Planning Application Reference No.: 3/2026/0629

Address of Development: 29 Chatburn Park Drive, Clitheroe, BB& 2AY

Comments: OBJECTION TO PLANNING APPLICATION

Proposal: Retrospective application for the retention of clear glazing in side elevation windows and rooflights.

3
EXISTING SOUTH
1 : 50

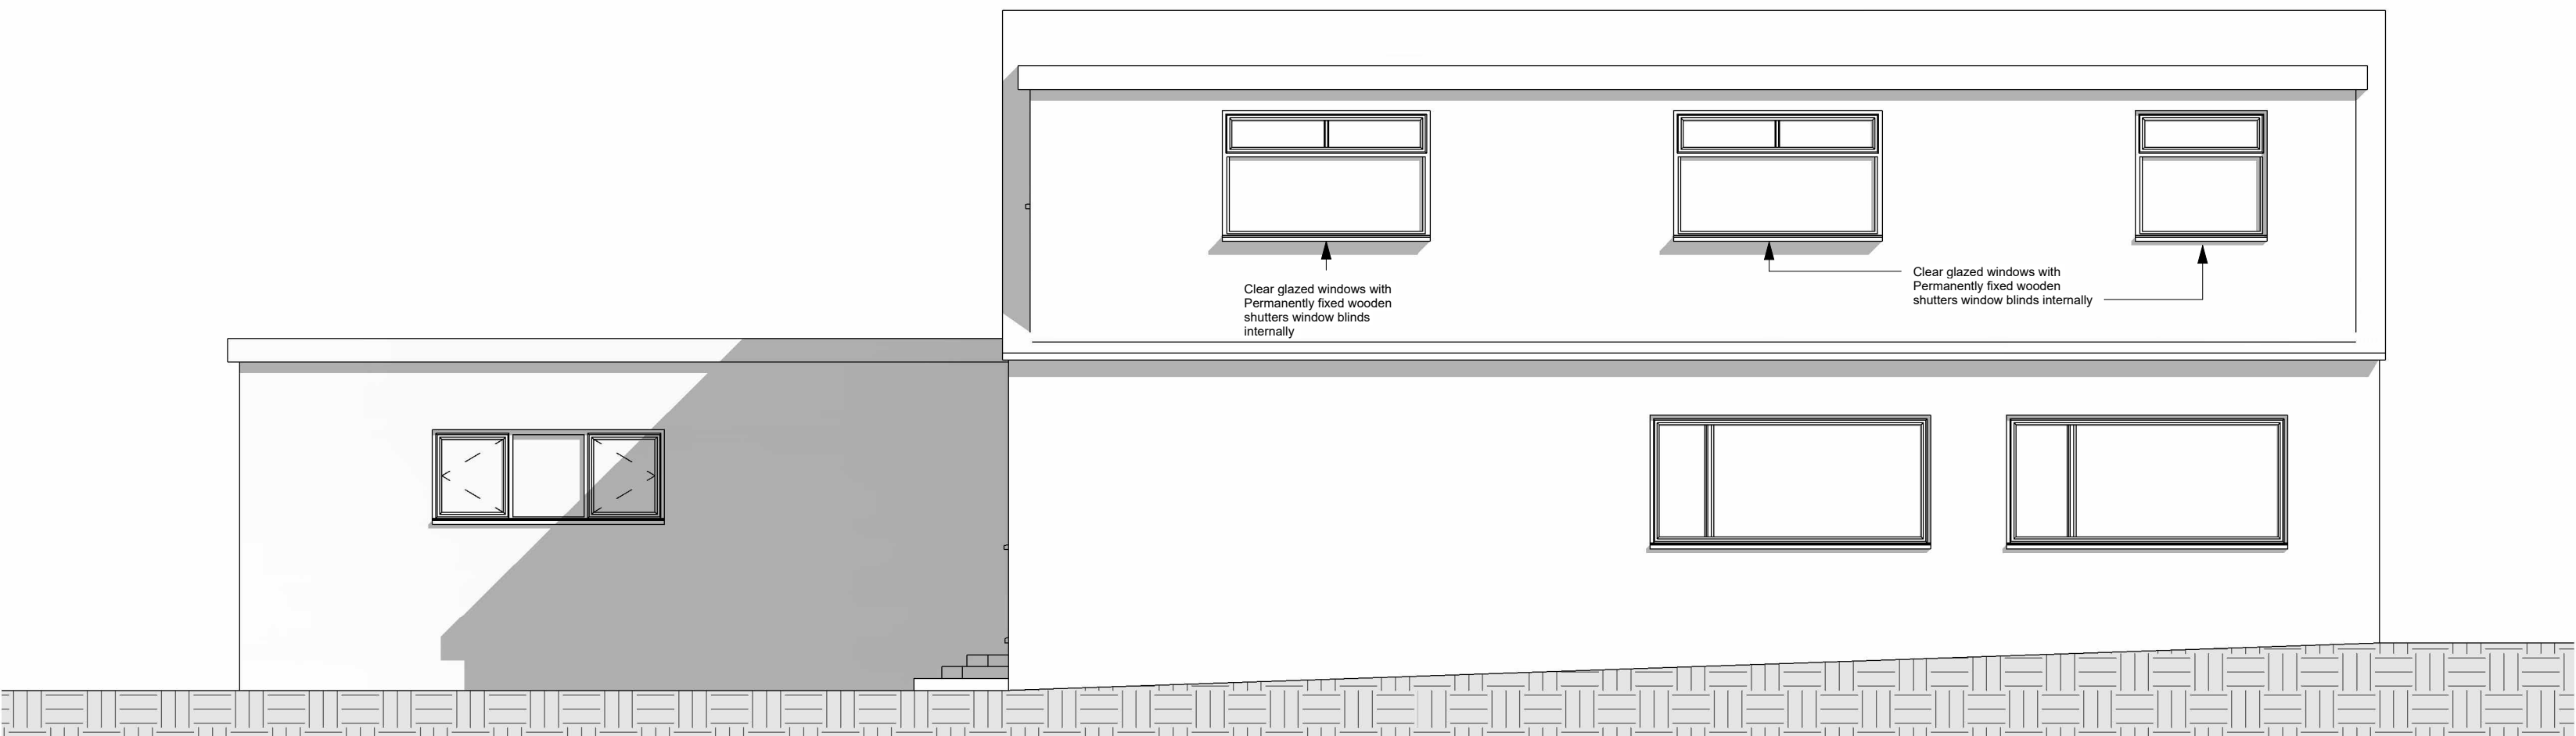
The two roof lights were only introduced in 2019 when a dormer extension was constructed on the existing south side of the application property as per the As Built Plan. The dormer and rooflights fell within permitted development rights, which required all window openings incorporated on side elevations to be obscure glazing. Obscure glazing was in place until it was removed by the applicant in early March this year after his recent purchase.

While the rooflights may sit at 1.7 metres internally on the As Built Plan, the insertion of clear glass creates a [REDACTED]. This creates an [REDACTED] significantly diminishing the quiet enjoyment of our [REDACTED] has been historically enjoyed since its original construction. Further, the constant opening of these rooflights means the [REDACTED]

The law explicitly mandates that any window or rooflight inserted into a side elevation slope must be obscure-glazed specifically to protect close-proximity neighbours from the above exact scenario.

[REDACTED] Pilkington Level 3 and/or fixed completely shut (or physically restricted via a built-in safety restrictor to a top-hinge opening mechanism that allows a maximum opening gap of no more than 100mm for ventilation purposes only) to prevent any [REDACTED]

Notes.		
notes.		
Project .		
As-Built Dormer Windows and rooflights @ 29 Chatburn Park Drive, Clitheroe BB7 2AY		
Client.		
Mark Woodcock		
drawing title.		
As-Built SITE PLAN		
status.		
scale.		
1:250 AT A3		
Drawn by:	DH	checked PH
Date.		
11/08/26		
project no.	dra. no.	rev.
PHA/1161	A2.2	-

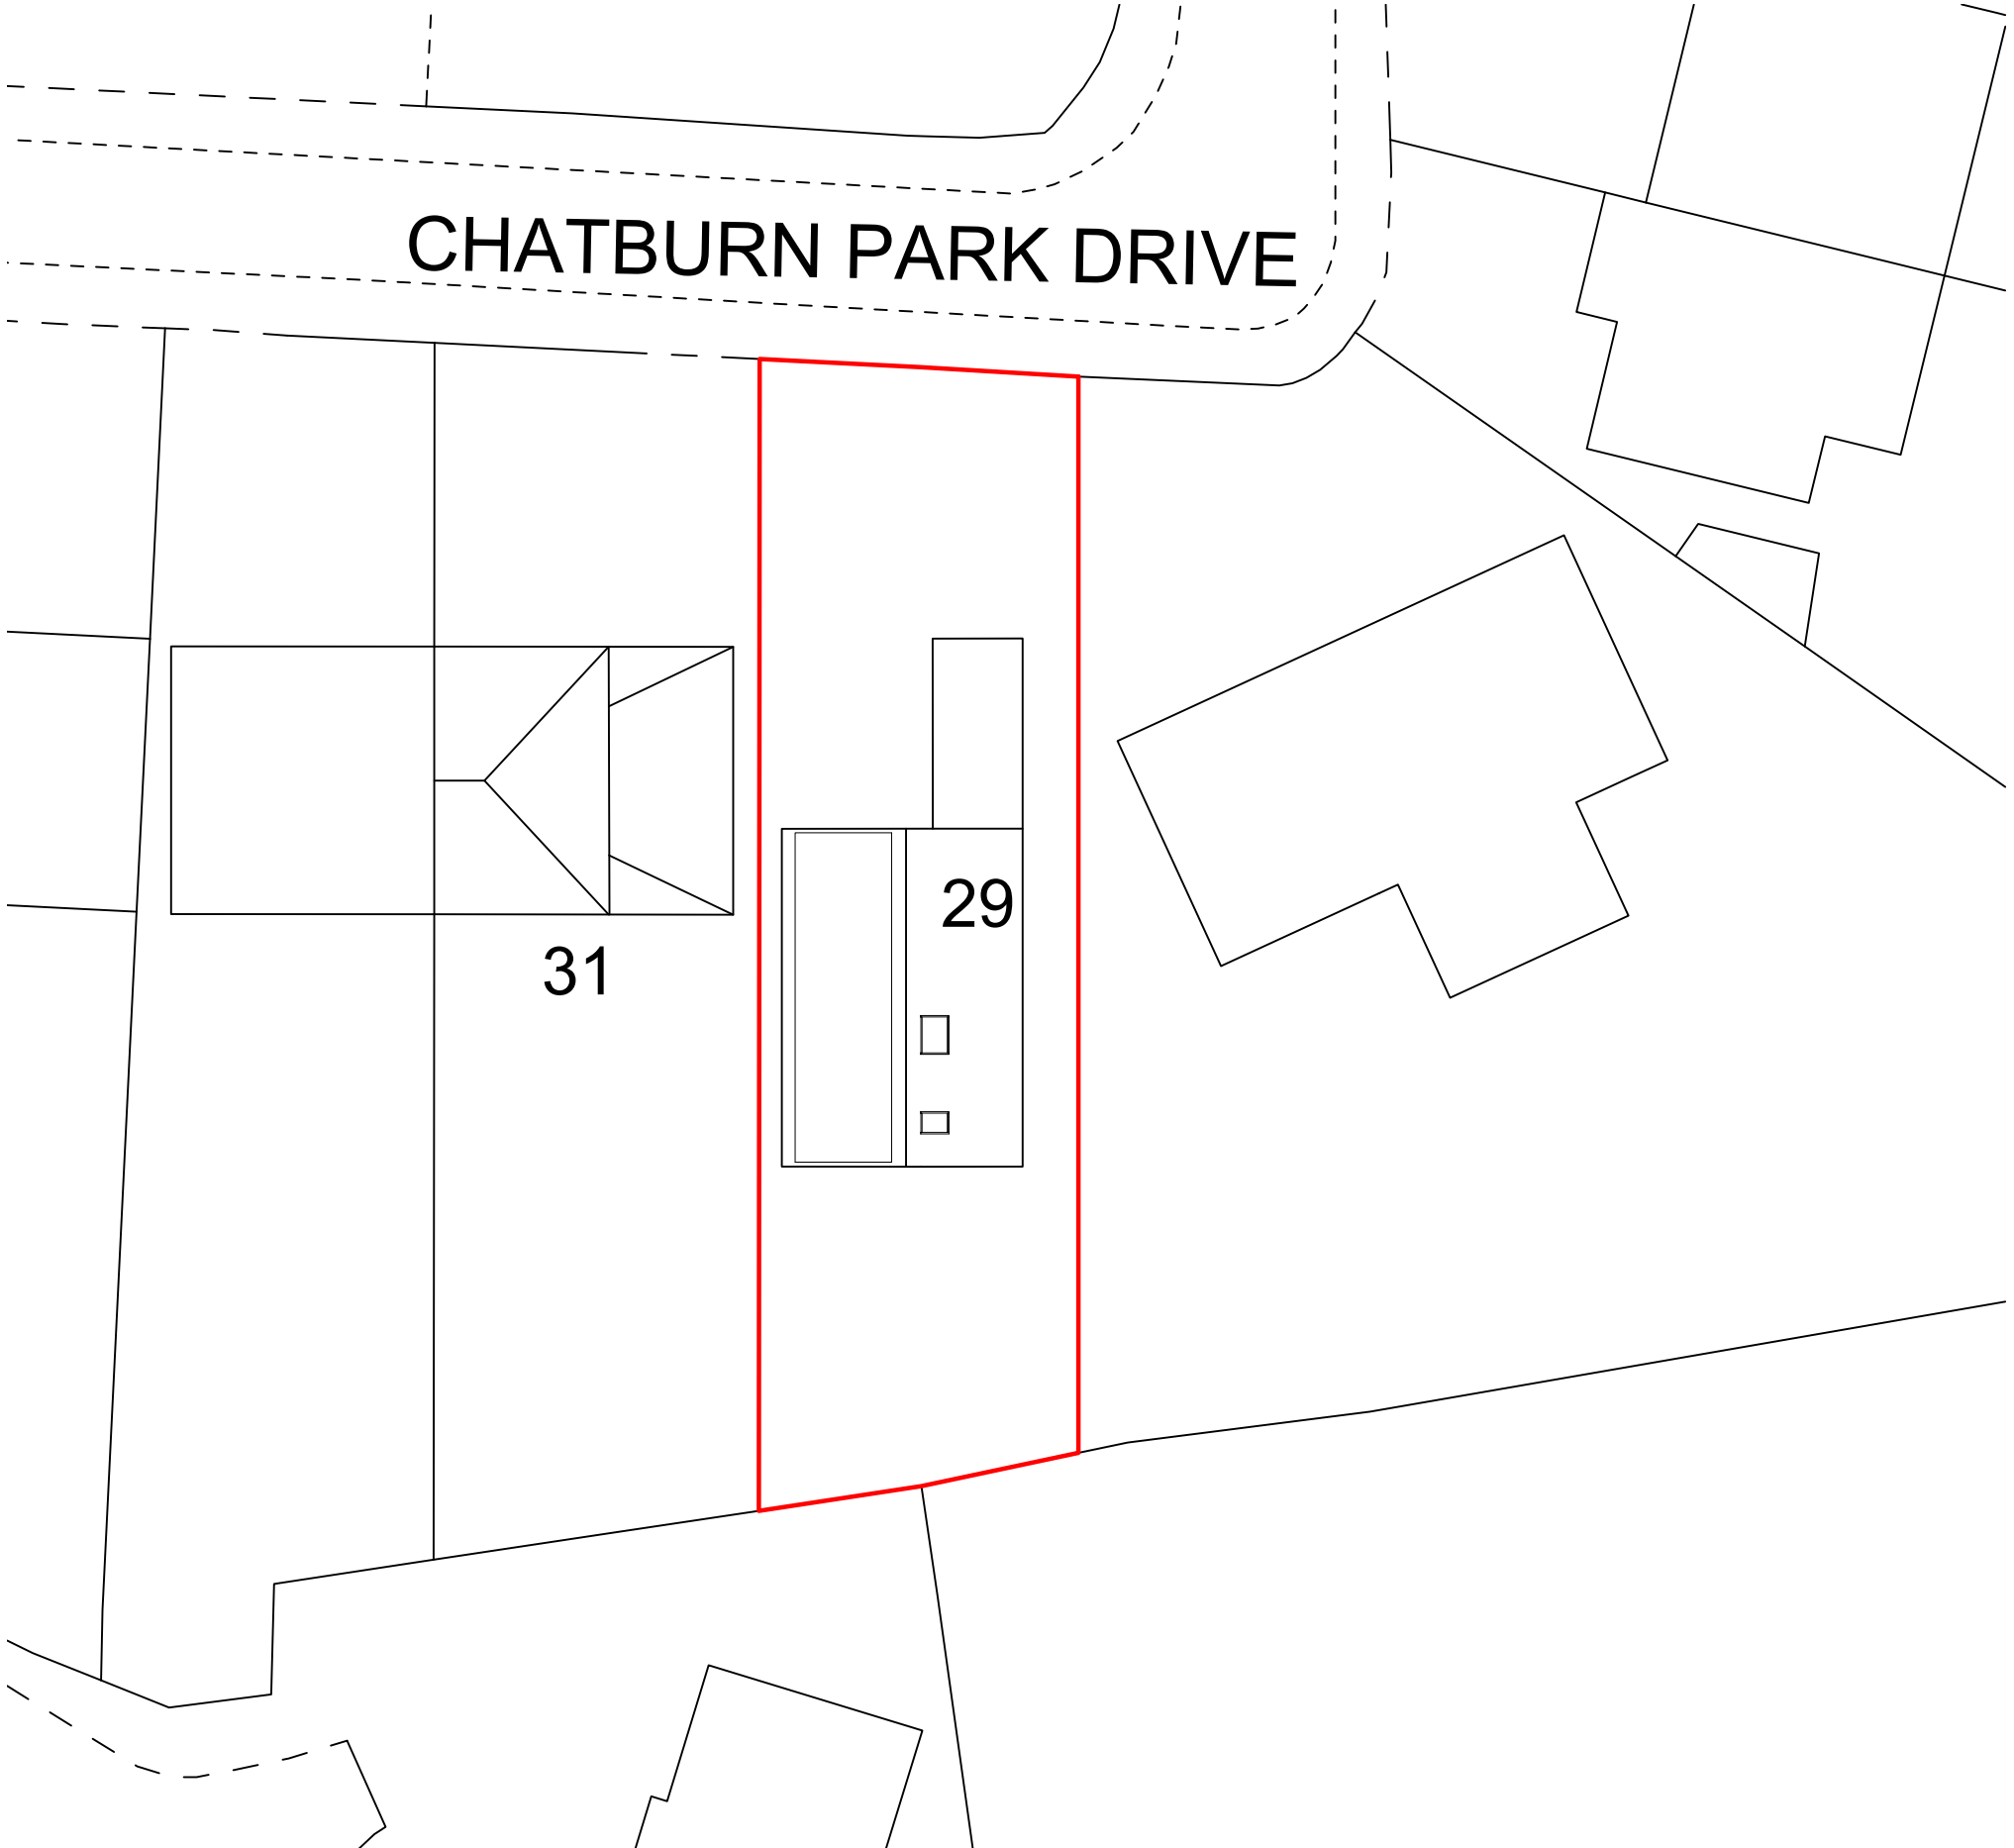
By way of background, the application property is a sideways-oriented bungalow built on a highly constrained, compact plot dating back to 1950/60. This can be seen from the site plan served with the application but is best viewed by way of a site visit which we invite the LPA to do before determining the application unless it is satisfied on paper that the same should be refused.

The application property protrudes far further back than the adjacent properties due to its sideways orientation, as can be seen from the site plan served with the application. This means that the application property protrudes back over half its length [REDACTED]. Whilst not measure has been taken it is also in very close in [REDACTED] be seen from the plans or a site visit.
